Our Ref: 1647/20

Your Ref: PP-09404156

Non-Material Alteration to EP/119/20/HH; Single storey pitched and flat roof additions; extended garage, new porch, dining area, and studio to 5 Selehurst Close East Preston BN16 2SR

**Drg No:** 1647/20/P/02A

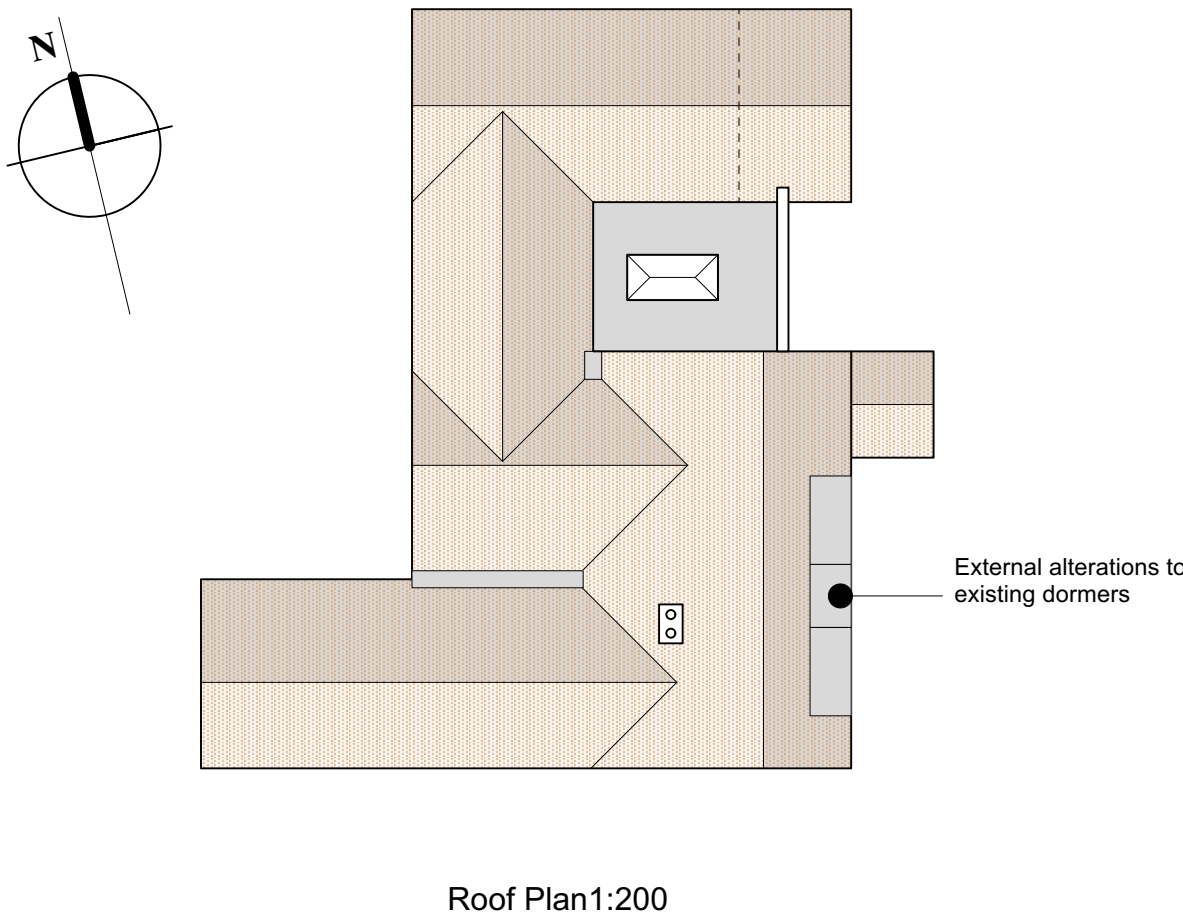
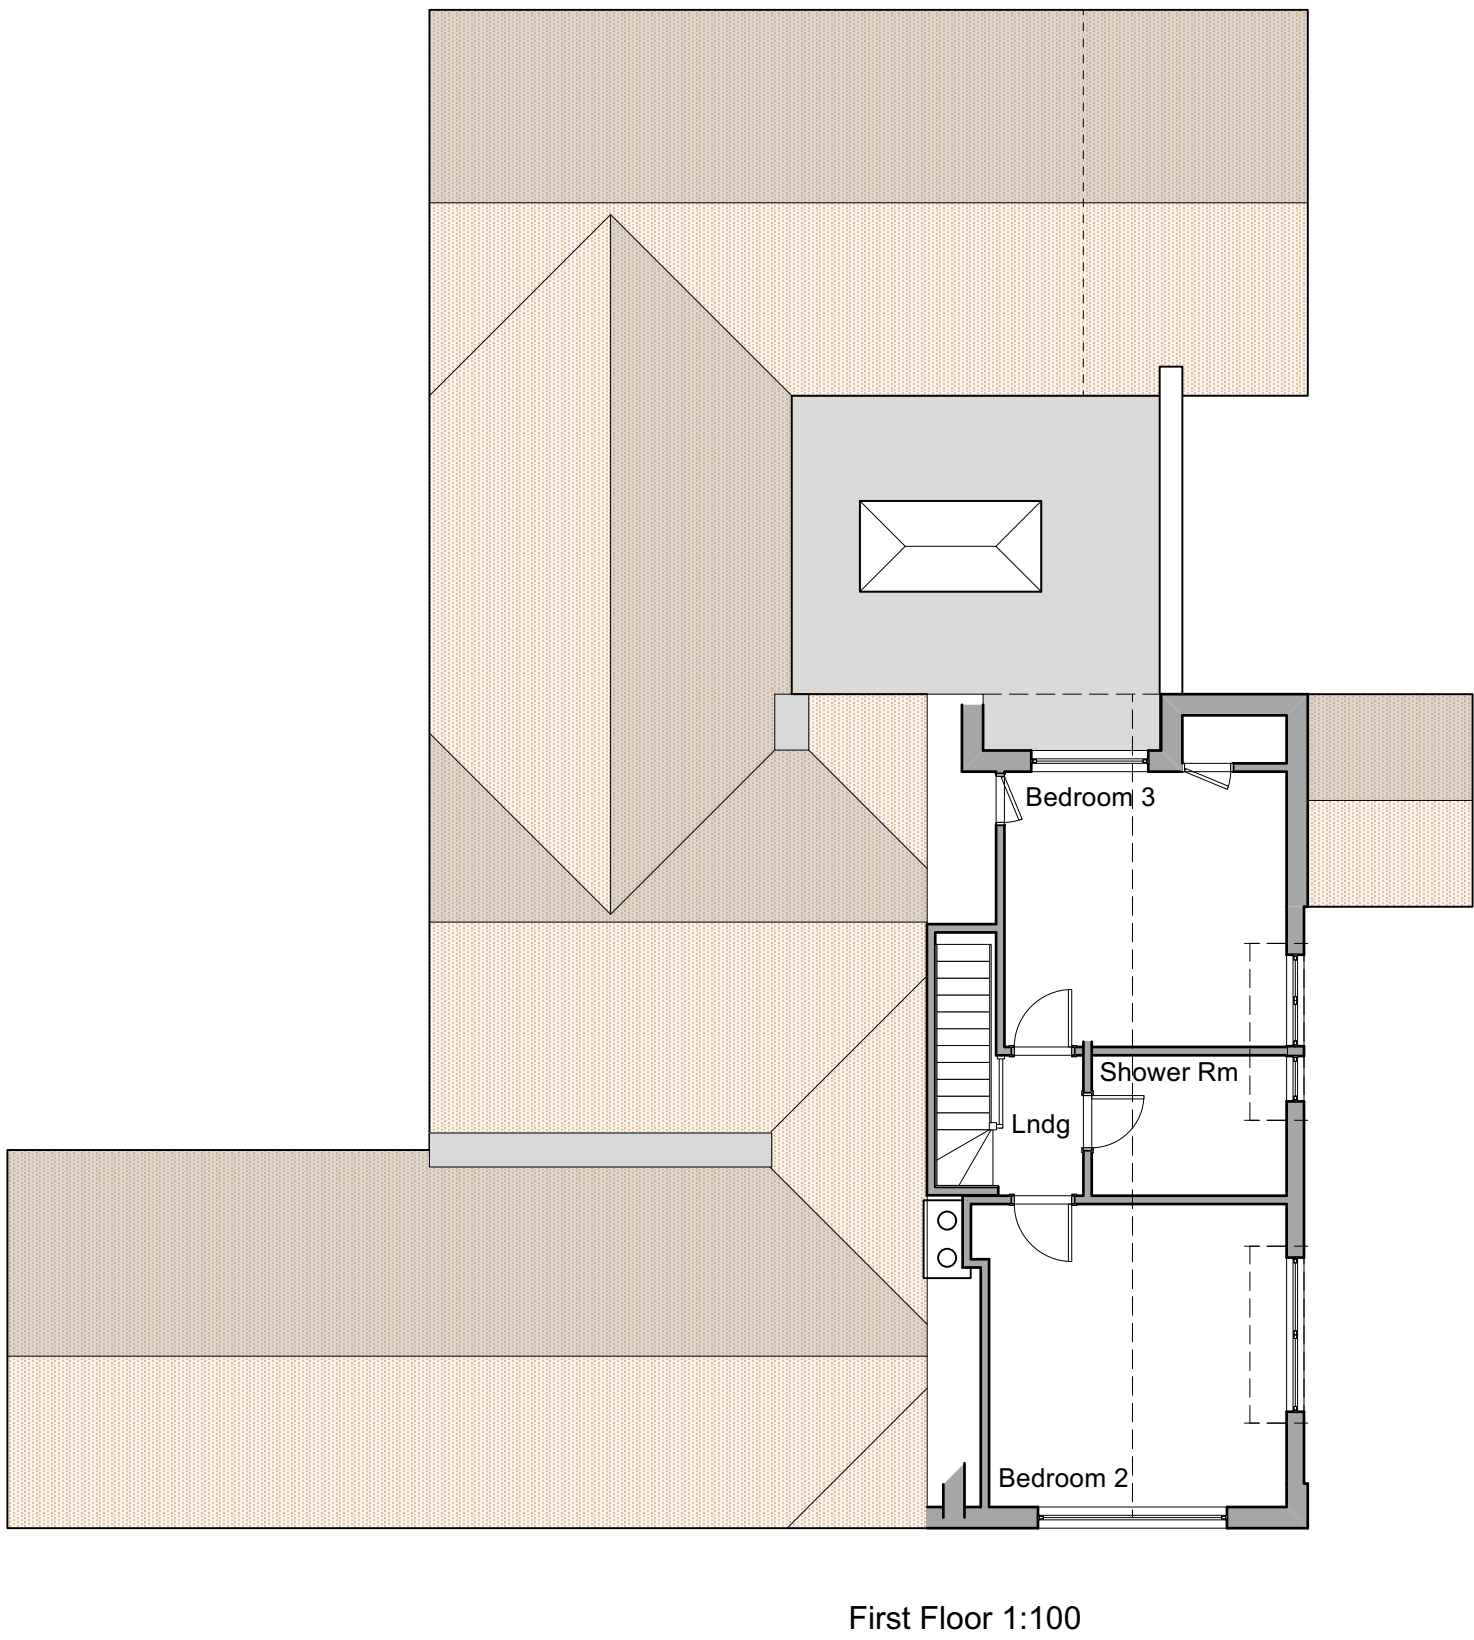
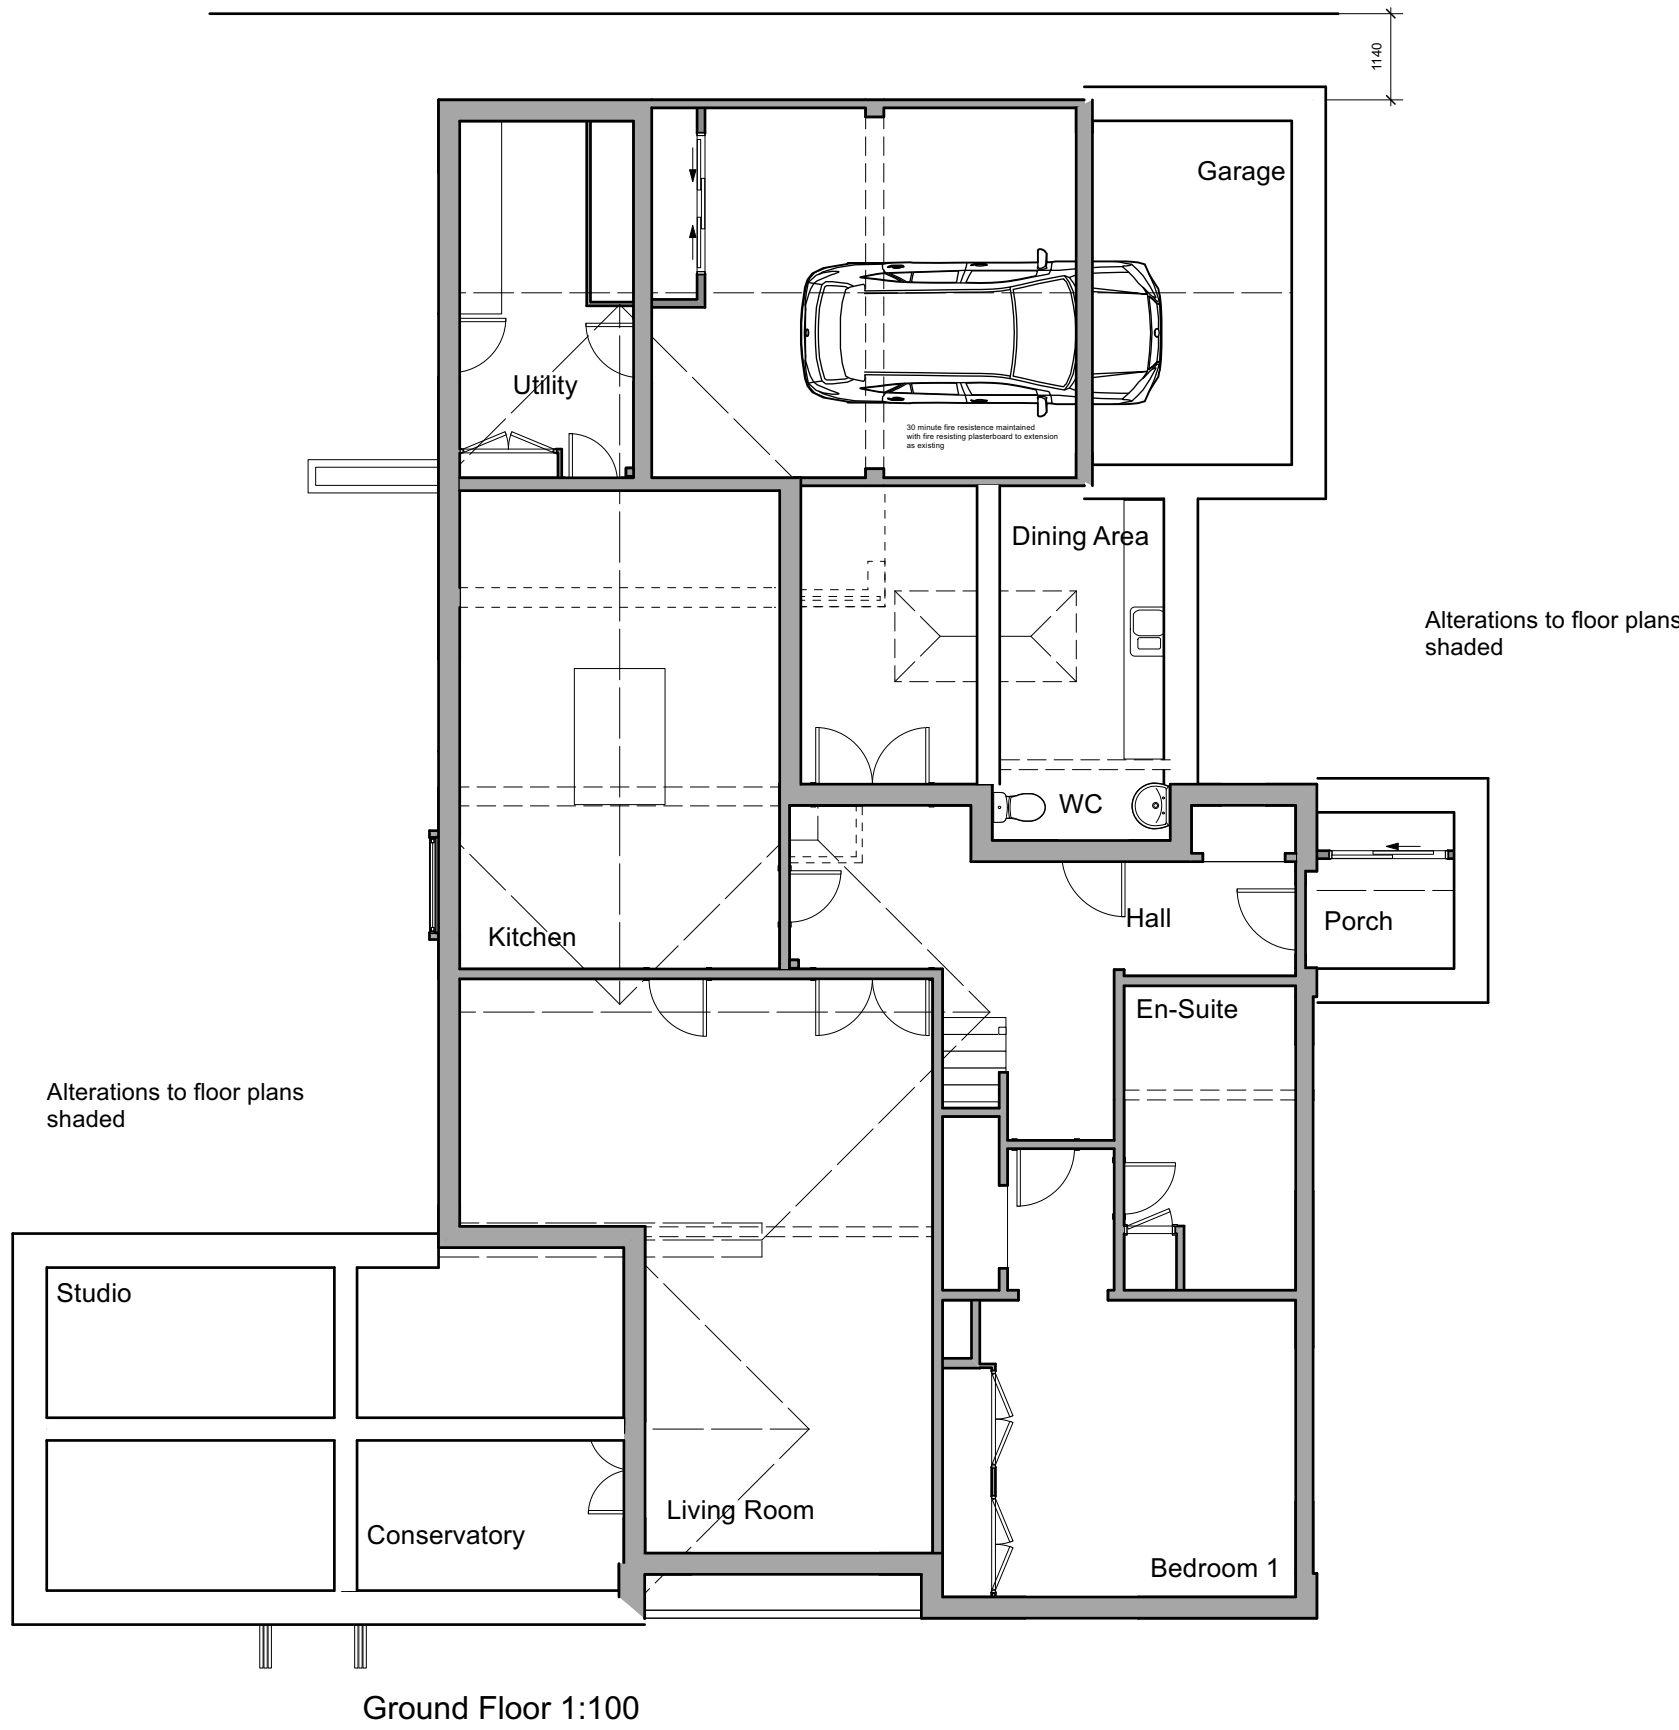
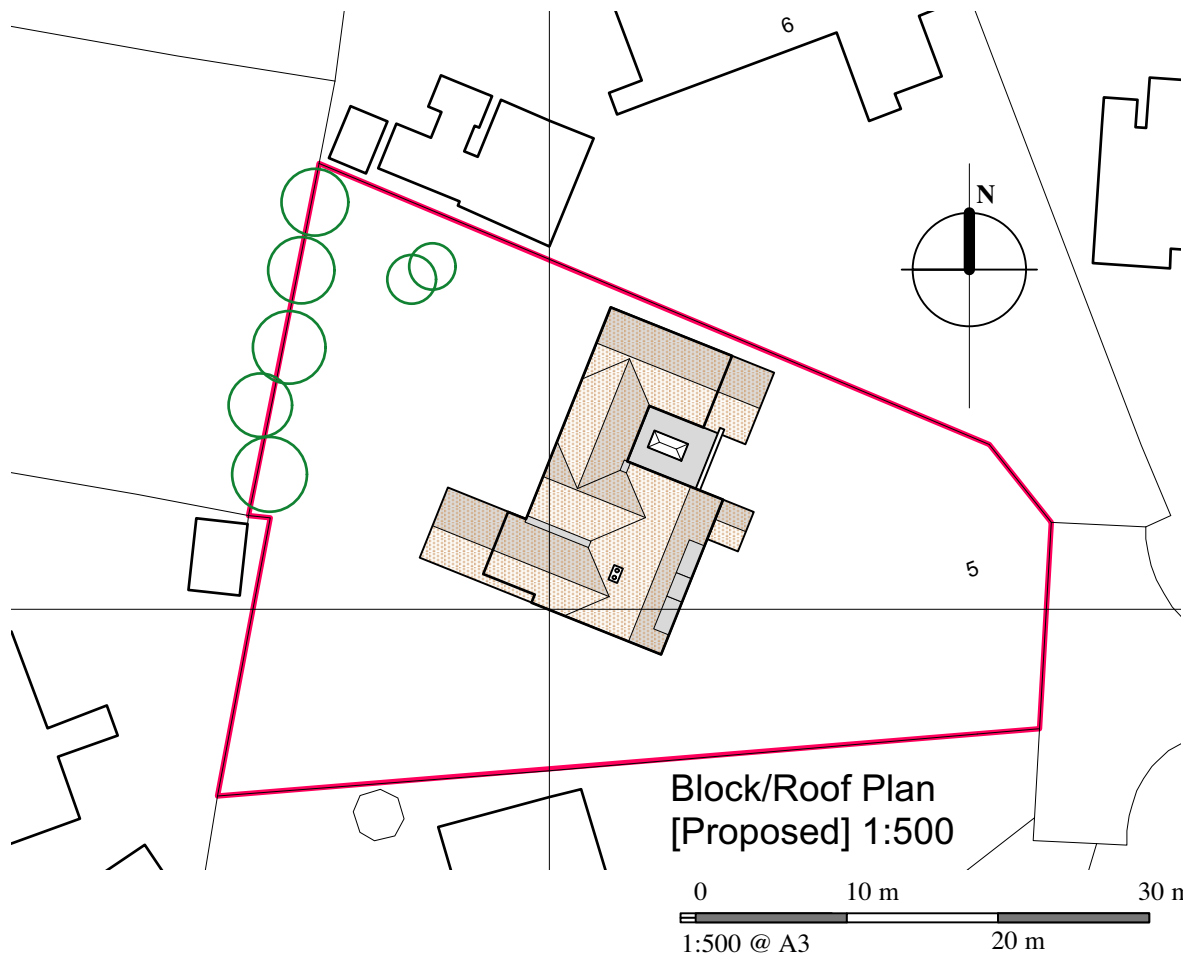
The proposal is illustrated within drawing 1647/20/P/02A. For ease of reference the approved drawing, 1647/20/P/02, has been submitted for comparison of the modest alteration to the dormers facing Selhurst Close.
